Planning Application: 3/2021/0532

**Proposed tennis court within the residential curtilage of Coppy House.
Coppy House, Mill Lane, Gisburn**

Planning Officer (Archaeology)
Historic Environment Team

PROPOSED TENNIS COURT PLAN
Scale 1:100

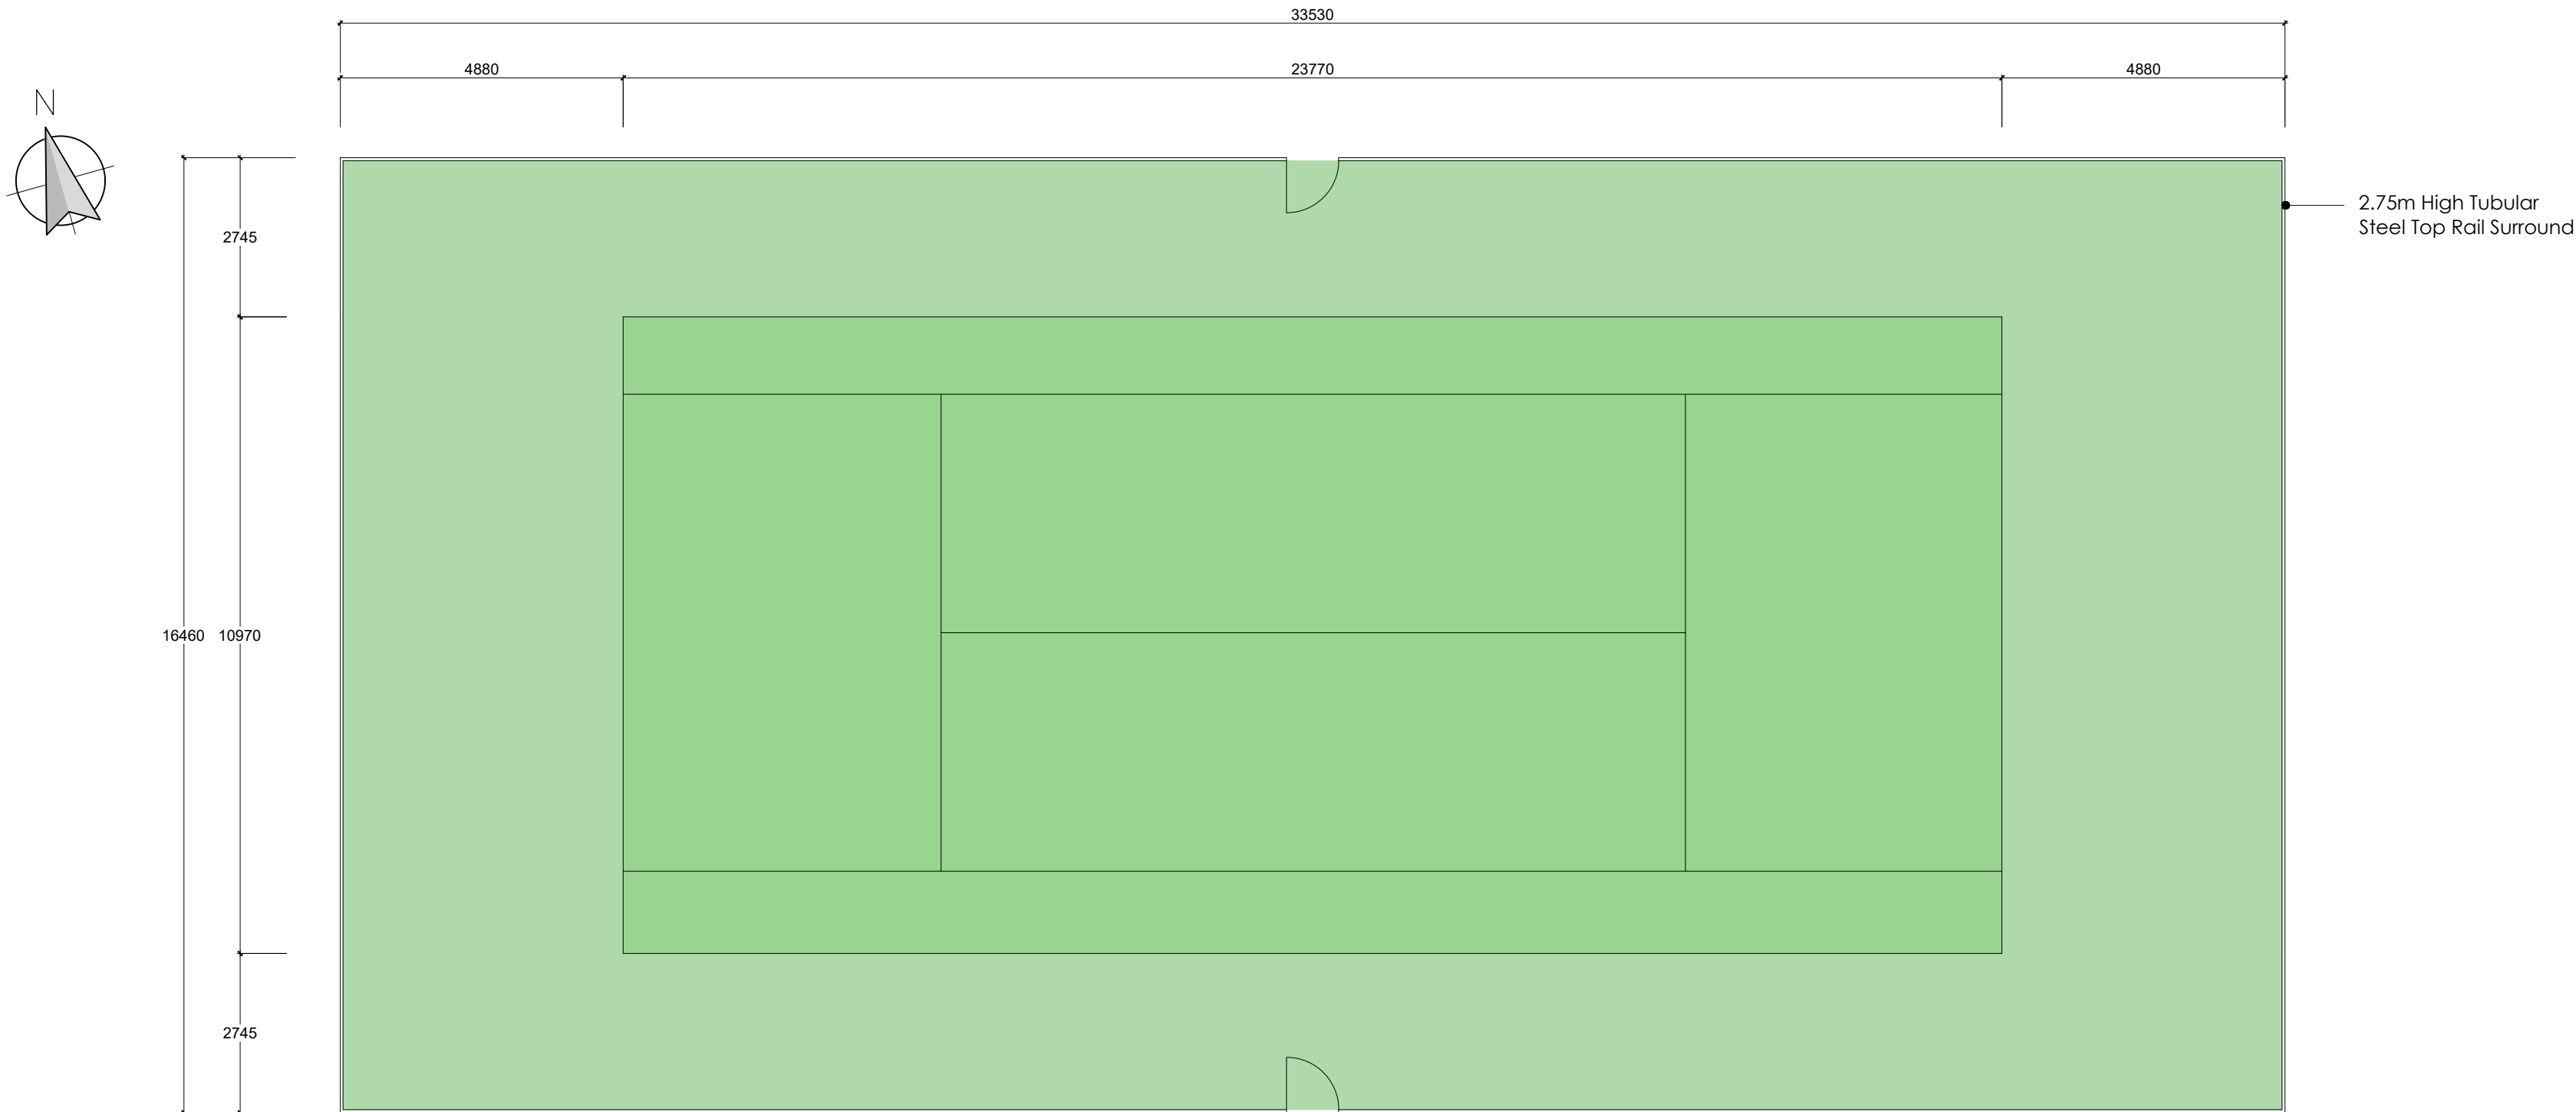
The proposed tennis court lies with the former limits of an early 18th century formal garden and deer park associated with Gisburne Hall, a non-designated heritage asset, recorded on the Lancashire Historic Environment Record, PRN37137.

The 1st Edition 1:10560 Ordnance Survey (Yorkshire Sheet 166, surveyed 1849-50) shows the proposed area for the tennis court crossed by 'paling'. On other deer parks in Bowland this is thought to have taken the form of both a closed and open timber fence, and by the 19th century may have also incorporated the use of iron, set atop a bank, which was accompanied by a corresponding ditch.

There is a potential that ground preparation works for the tennis court may encounter evidence for this former deer park boundary feature.

Consequently, should the Local Planning Authority be minded to grant planning permission to this, or any similar scheme, the Historic Environment Team would advise that an archaeological watching brief be maintained during groundworks and that such work is secured by means of the following condition:

Condition: No development shall take place until the applicant, or their agent or successors in title, has secured the implementation of a programme of archaeological work. This must be carried out in accordance with a written scheme of investigation, which shall first have been submitted to and agreed in writing by the Local Planning Authority.

Note: The programme of archaeological work should include a formal watching brief, followed by such subsequent work as required to investigate and record any remains encountered. This work should be carried out by an appropriately qualified and experienced professional archaeological contractor to the standards and guidance set out by the Chartered Institute for Archaeologists
